WEST SUSSEX COUNTY COUNCIL CONSULTATION

TO:	Arun District Council FAO: Amber Willard
FROM:	WSCC - Highways Authority
DATE:	7 March 2022
LOCATION:	23 Felpham Way Felpham PO22 8PT
SUBJECT:	FP/273/21/HH Extension to existing drop kerb to the right by 3.6 meters.
DATE OF SITE VISIT:	n/a
RECOMMENDATION:	Advice
S106 CONTRIBUTION TOTAL:	n/a

Location Plan

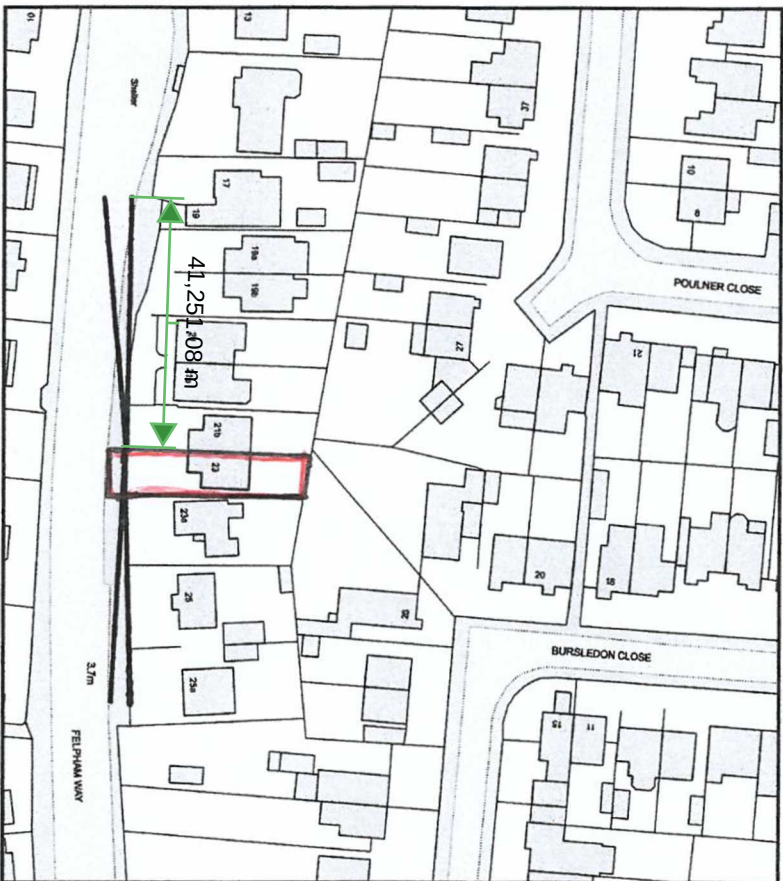
From an inspection of local mapping, it appears that the dwelling benefits from an existing dropped kerb, shared with property 21a. It is unclear from the plans how wide the existing shared vehicle crossover (VCO) is. The proposed extension of the VCO is 3.6 wide.

Whilst the LHA would not raise any highway safety concerns to the principle of the proposed widened VCO, a detailed plan demonstrating both the existing and proposed VCO widths would be required to be secured via condition - however, the LPA may wish to request this information prior to determination, to ensure that any approved widened VCO meets the requirements of the WSCC Area Office and does not result in an unimplementable planning permission.

Visibility at the proposed access has been demonstrated and the LHA is satisfied that sufficient splays are achievable in this location.

The applicant should be aware that the proposed VCO widening would be required to be constructed under licence from the Area Office and to a specification agreed with them. The applicant should be aware that a VCO of greater total width than 6.4m per dwelling would not be granted a licence by the Area Office.
